## Memorandum

**Re:** Desert Springs Church, Administrative Amendment Request Resubmittal  
– PR-2021-005784, SI-2021-01136

## Administrative Amendment Request

### Project #PR- 2021-005784

SITE PLAN
ZONING: MX-T
SCALE: 1" = 40'-0"

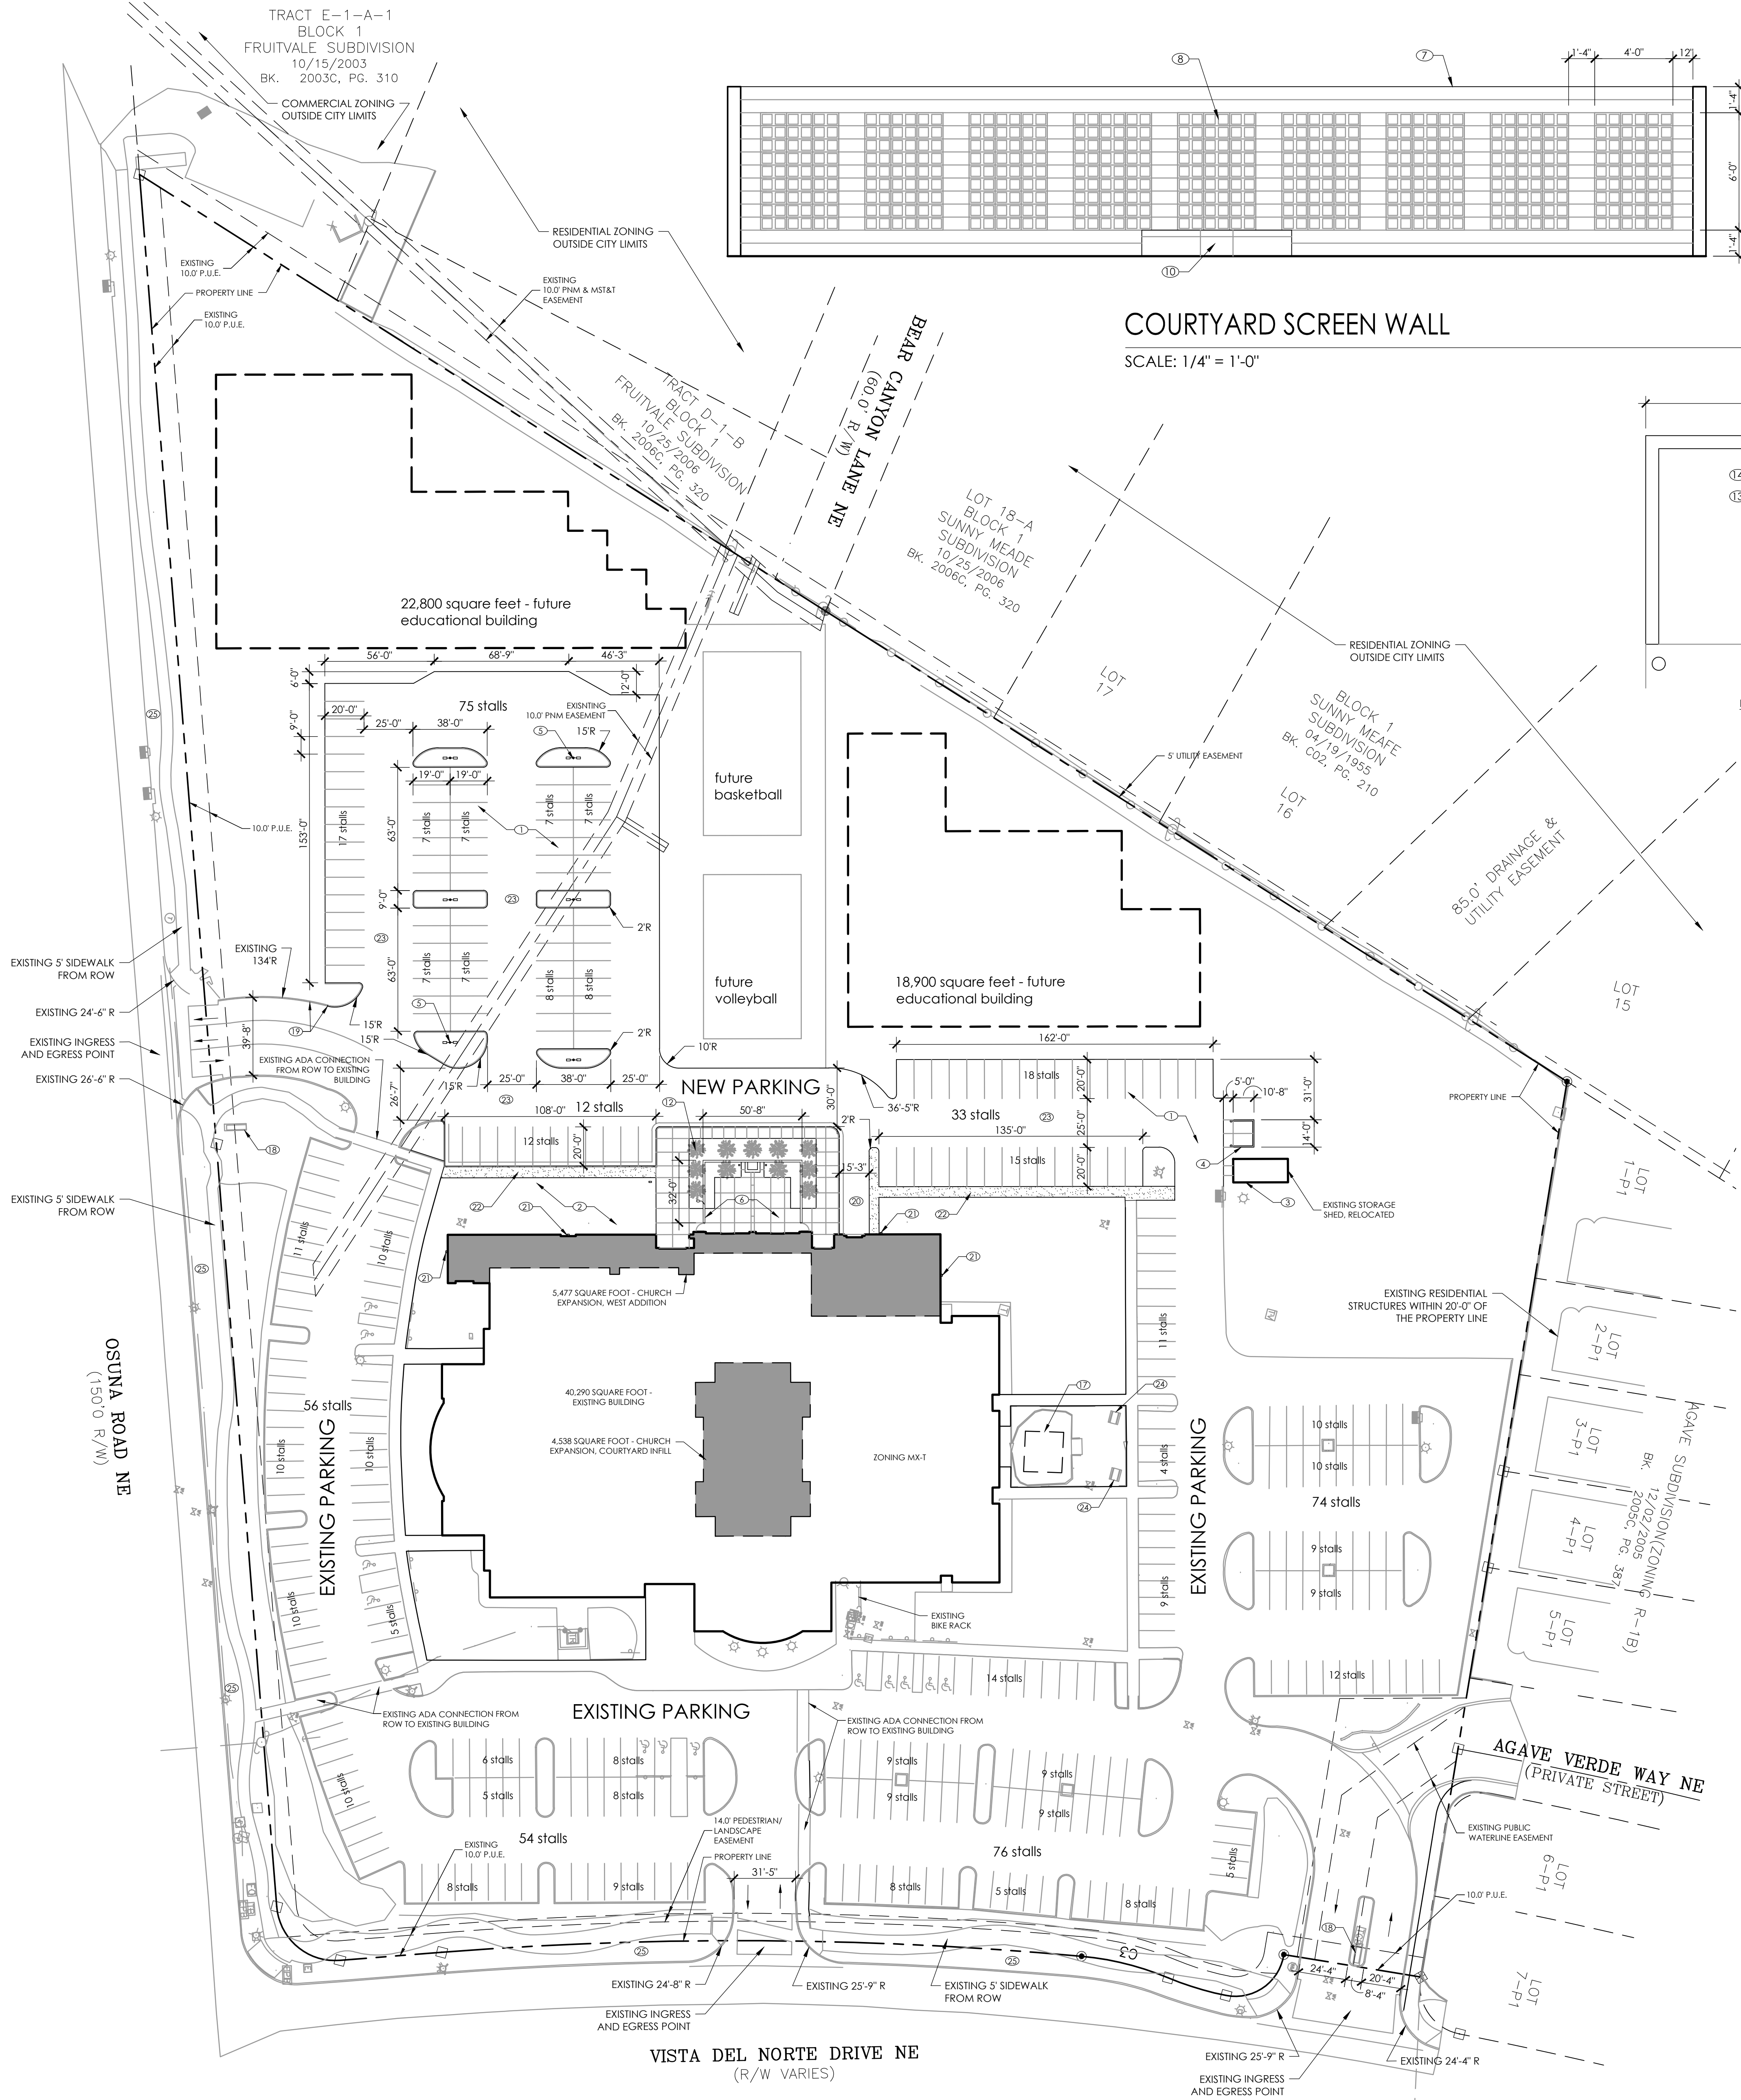
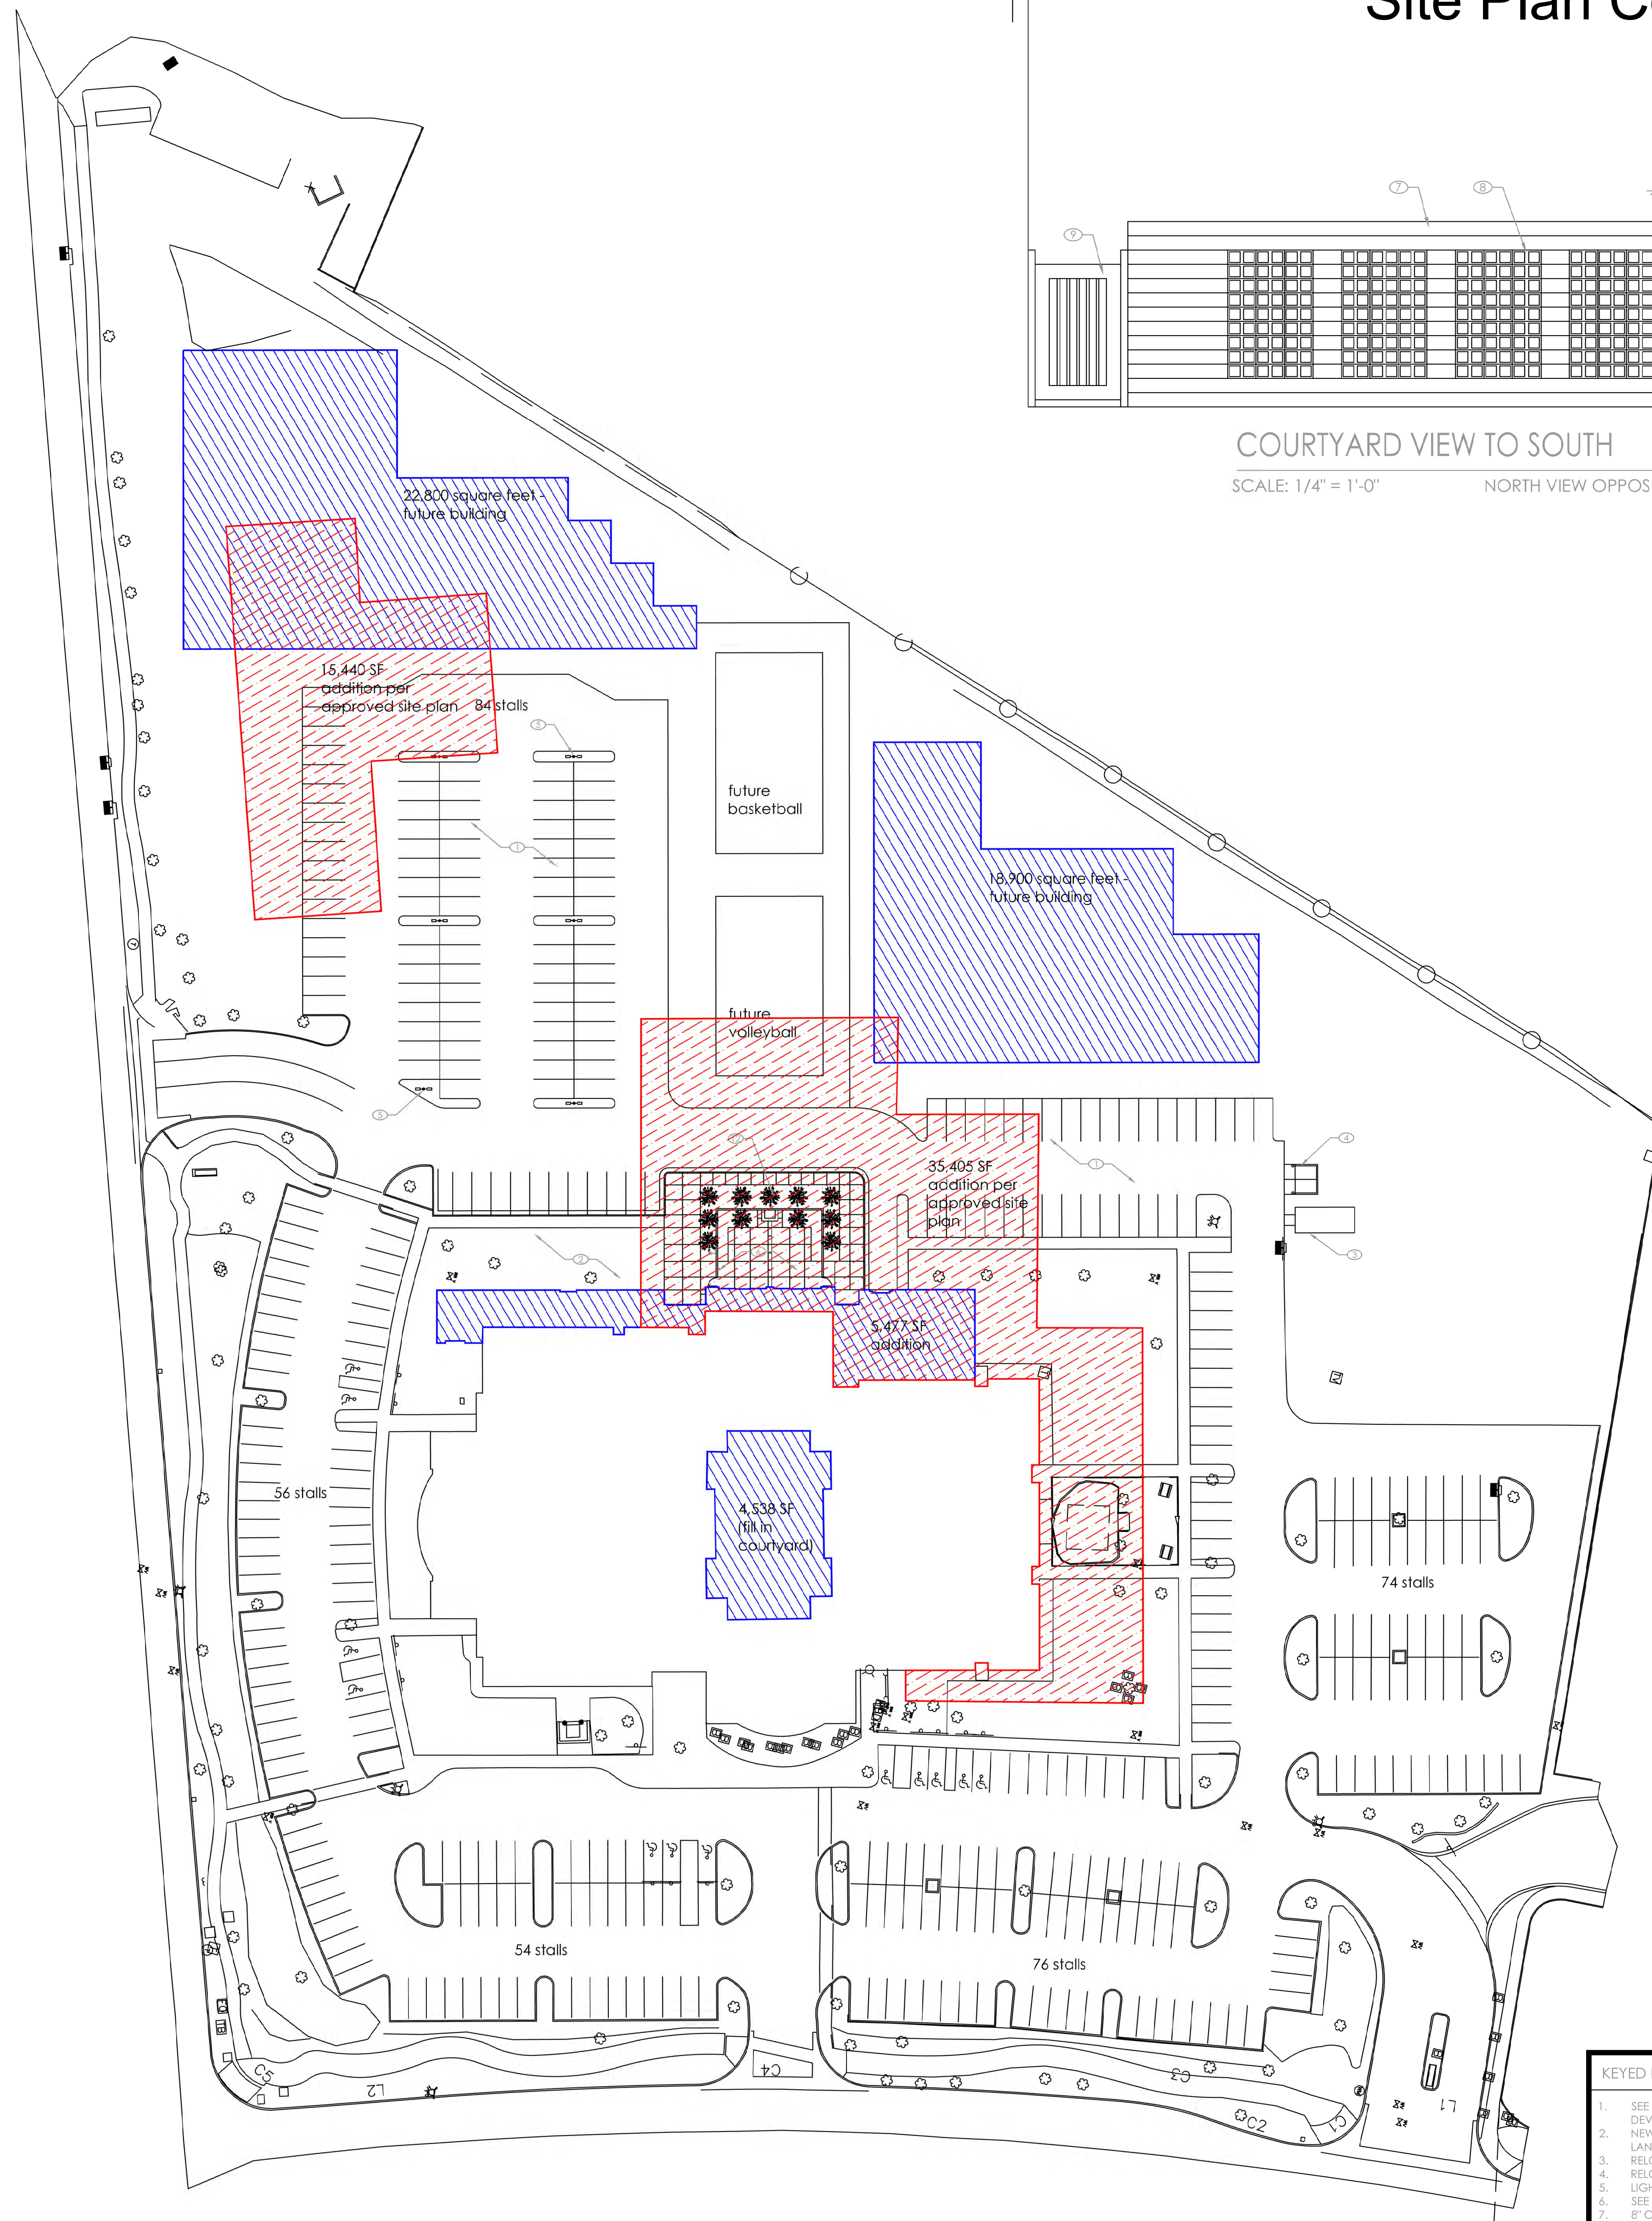
1. The 10-foot radius south of the future basketball courts is too tight a turning radius. Follow DPM standards for this one based on expected design vehicle.  
[This has been modified.](#)

2. Seek Solid Waste Approval prior to approval by the Transportation Department.  
[We have initiated the process. We are waiting for response.](#)
3. For each segment of the parking lot, provide typical parking stall width and length. If the radii for the landscape islands are typical, add the note "Typical" to one of them.  
[All radii are marked. We've added "Typical" to the parking stall dimensions.](#)

4. Show 6-foot ADA pathway to right-of-way from the main building, and label all proposed and existing pedestrian pathways to demonstrate existing ADA access.  
[ADA access pathway is existing and is 5' wide. We've added graphic pattern to illustrate access passage to building.](#)

5. Label new asphalt parking lot as an asphalt surface if this is the intent, and add a keyed note calling out all curb. Curb that separates the parking lot from the landscape islands and pedestrian ways shall be between 6" to 8" high.  
[Curb detail is shown on the grading and drainage plan. We've added additional notes indicating that the curb is 6" high.](#)

7. Follow IDO Standards for addition of motorcycle parking and bicycle parking. Add necessary dimensioning for these, motorcycle parking sign details and bicycle rack details.  
[Motorcycle parking and bicycle parking are added including dimensions and detail.](#)
